CITY OF ALBUQUERQUE

RE: **Blakes Lotaburger**
1640 Gibson Blvd SE
Grading and Drainage Plan
Engineer's Stamp Date 3/27/17 (File: M15D012A)

Based upon the information provided in your submittal received 3/27/17, the Grading and Drainage Plan is approved for Grading and Building Permit with the following recommendation:

PROJECT TITLE	BLAKE'S LOTABURGER	DRAWN BY:	JEFF WOOTEN
1640 GIBSON BLVD. SE	ALBUQUERQUE, NEW MEXICO 87106	JOB NO.	2016033
PROJECT MANAGER	JEFF WOOTEN	SHEET TITLE	Grading Plan

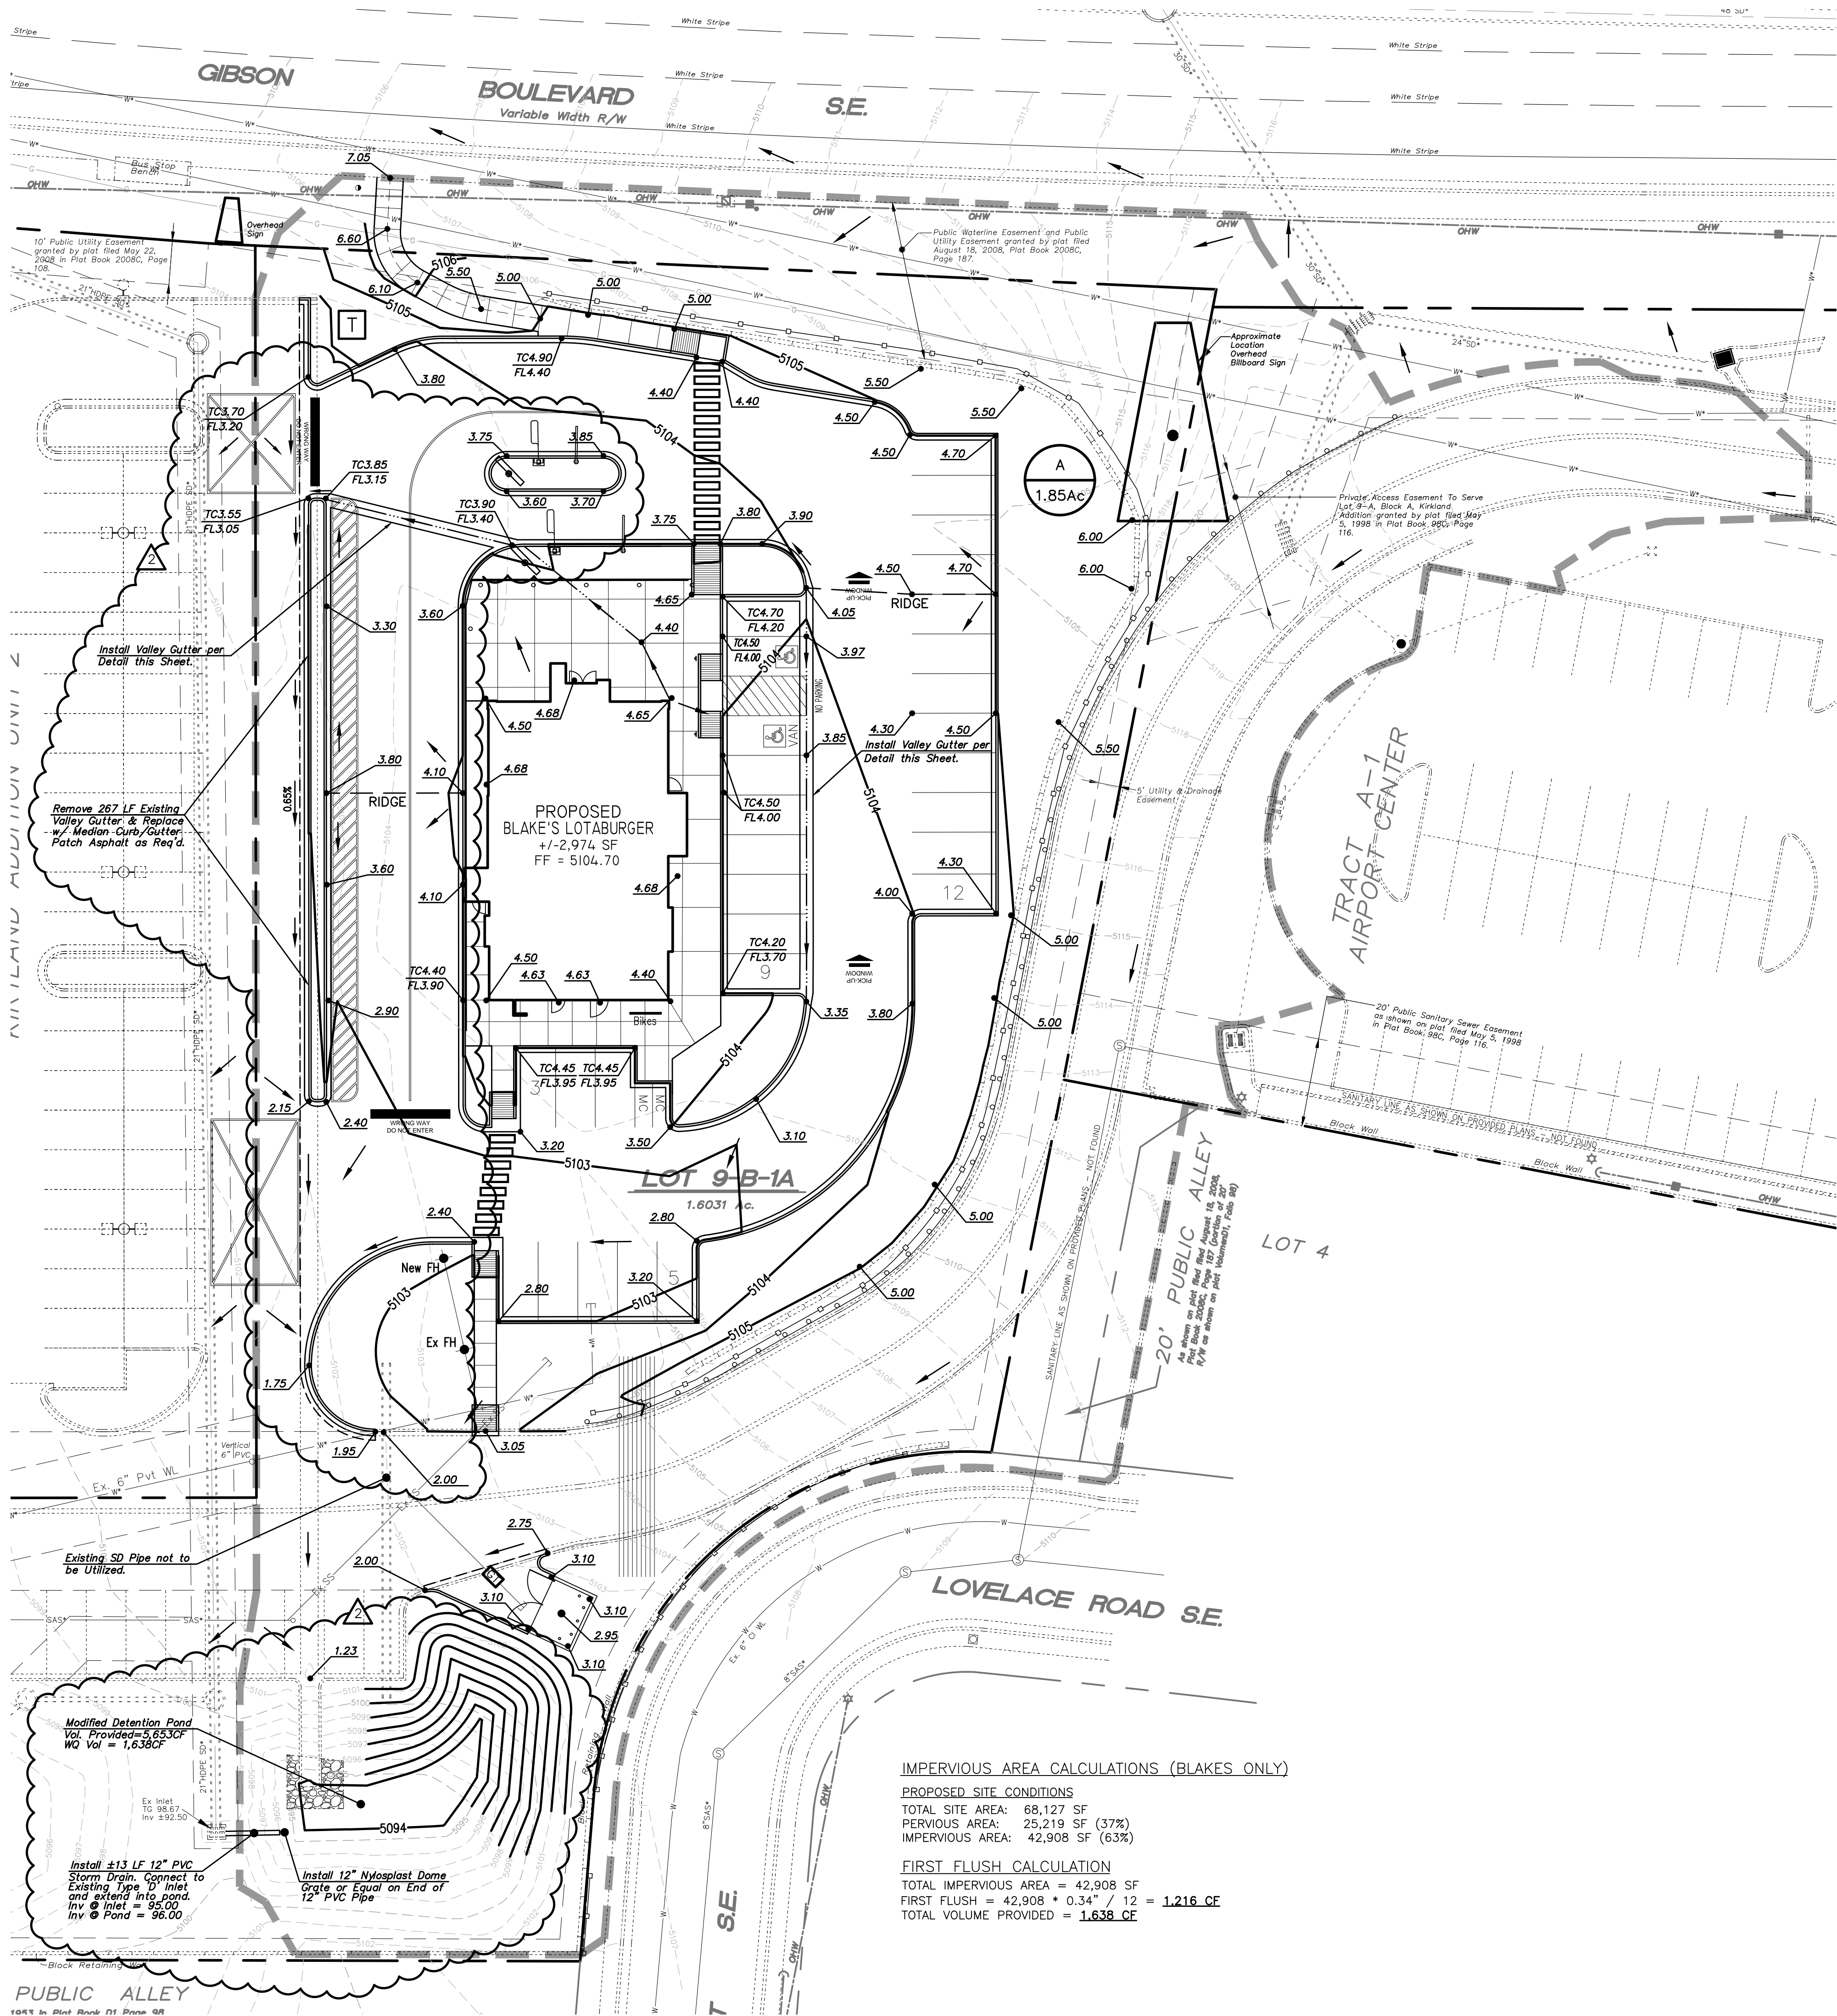
1. Provide additional curb cuts at low spots for the ponds to capture additional runoff.
